Subject: FW: FW: R/73/20/DOC - Condition 6 of R/201/19/PL - 106 The Street, Rustington

Thank you for forwarding Anderson Acoustics' Pre-completion Sound Insulation Testing report (ref.: 4757_001R_1-0_BP, dated June 2020) and associated photographs.

Standardized level difference according to BS EN ISO 140-4

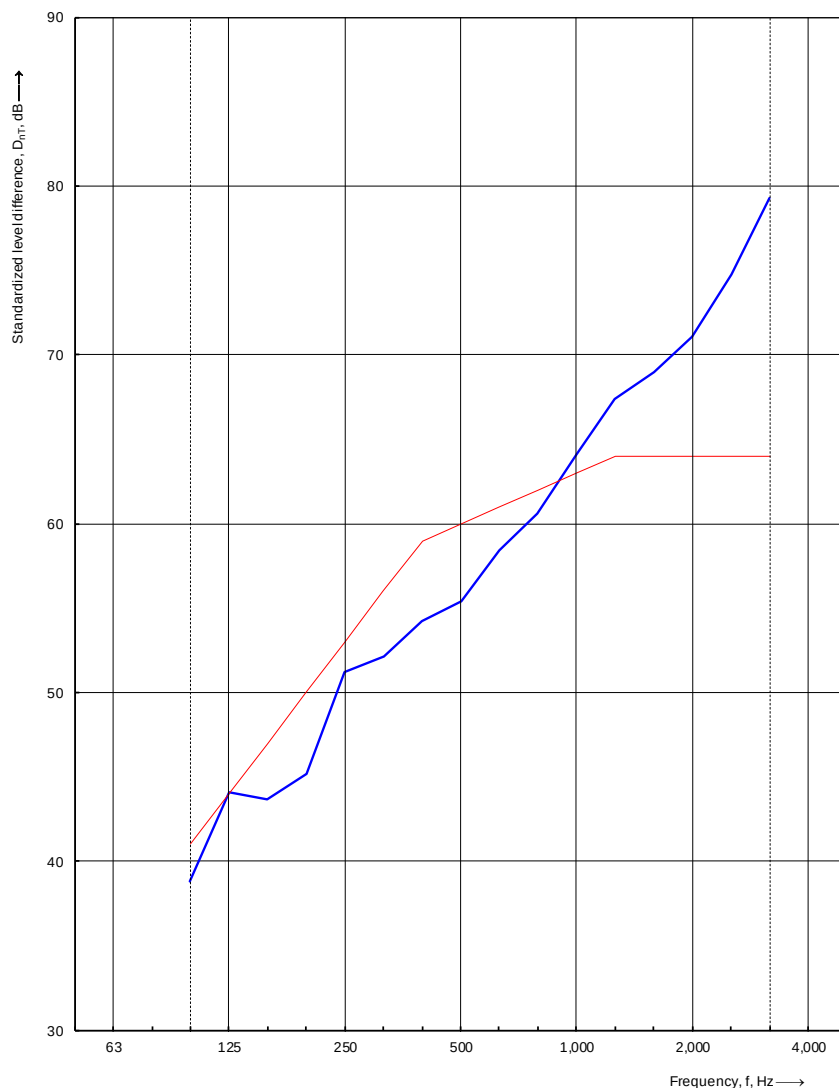
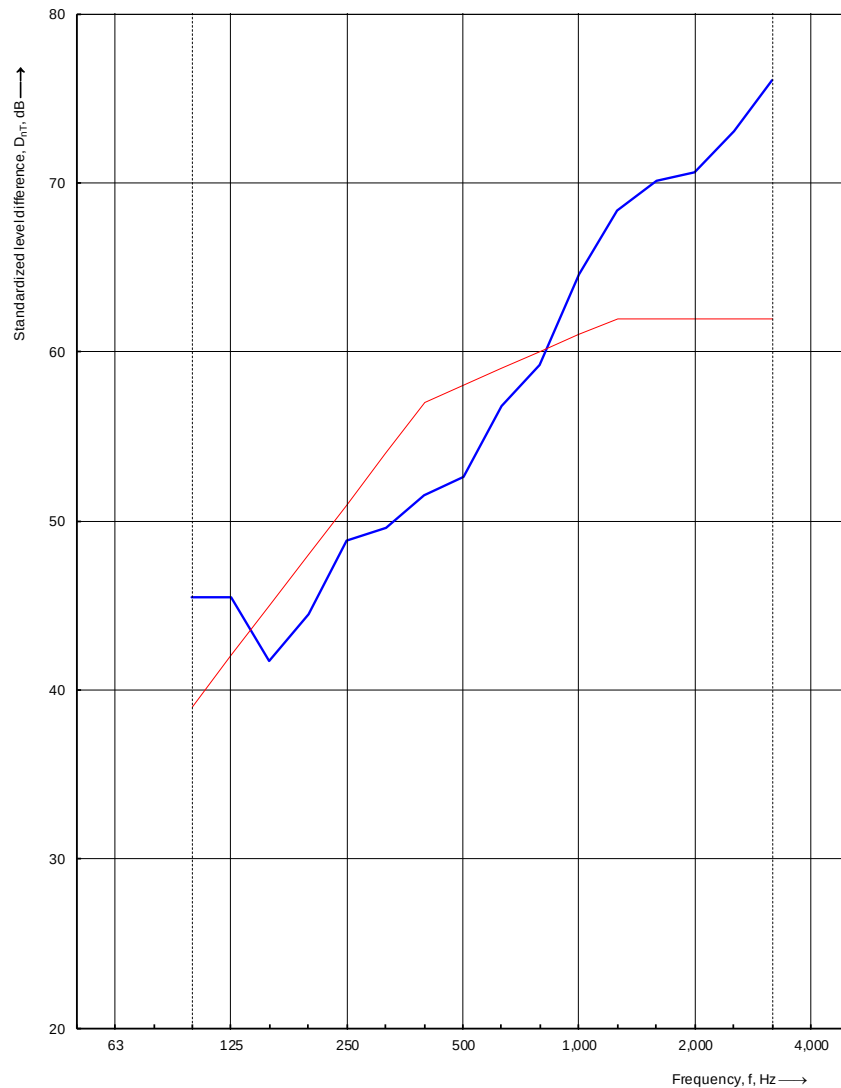
Having now reviewed this report, it is not possible at this stage to recommend that the relevant condition can be discharged. The report references Approved Document E which is a Building Regulation publication. Furthermore, it is my understanding that Approved Document E relates to residential properties and not buildings in commercial use.

As previously advised, this Department would expect that a suitably qualified, independent acoustician is employed to establish the location of the nearest noise sensitive receptor(s), calculate the likely sound levels (to include tonality, etc.) from the proposed use and ascertain whether this is likely to be problematic for the occupiers of the previously identified receptor(s). Based on this, an appropriate acoustic attenuation scheme can be designed. Once the local planning authority has approved the scheme, works can commence and once completed, a test shall be undertaken to ensure the scheme is effective. The submission received to date does not adequately address these requirements.
